## Fire Marshal Division

**RE: Biscuitville Restaurant**  
**1608 NC 24-87 Hwy**  
**Cameron, NC 28326**

**Application Number BCOM1809-0006**

SIZE	DWG #	DWG	REV
		KITCHEN FIRE SYSTEM	1
SCALE	N/A	SHEET	1 OF 5

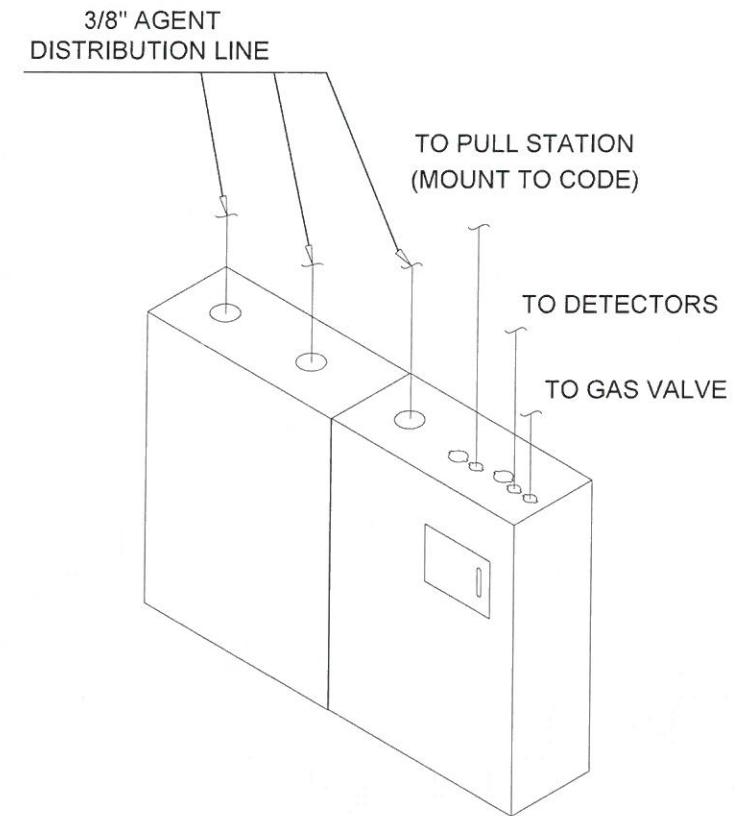
- **Commercial cooking equipment.**
  - Portable fire extinguishers shall be provided within a 30-foot (9144 mm) travel distance of commercial-type cooking equipment. Cooking equipment involving vegetable or animal oils and fats shall be protected by a Class K rated portable extinguisher.

- **Manual system operation**
  - A manual actuation device shall be located at or near a means of egress from the cooking area, a minimum of 10 feet (3048 mm) and a maximum of 20 feet (6096 mm) from the kitchen exhaust system. The manual actuation device shall be located a minimum of 4.5 feet (1372 mm) and a maximum of 5 feet (1524 mm) above the floor. The manual actuation shall require a maximum force of 40 pounds (178 N) and a maximum movement of 14 inches (356 mm) to actuate the fire suppression system.

- **System Interconnection**
  - The actuation of the fire suppression system shall automatically shut down the fuel or electrical power supply to the cooking equipment. The fuel and electrical supply reset shall be manual.
- **Notes**
  - Please schedule all fire inspections through the Fire Marshal's Office.
  - Contact Number **910-984-4003**.
  - Please provide system certification certificate from installing contractor.
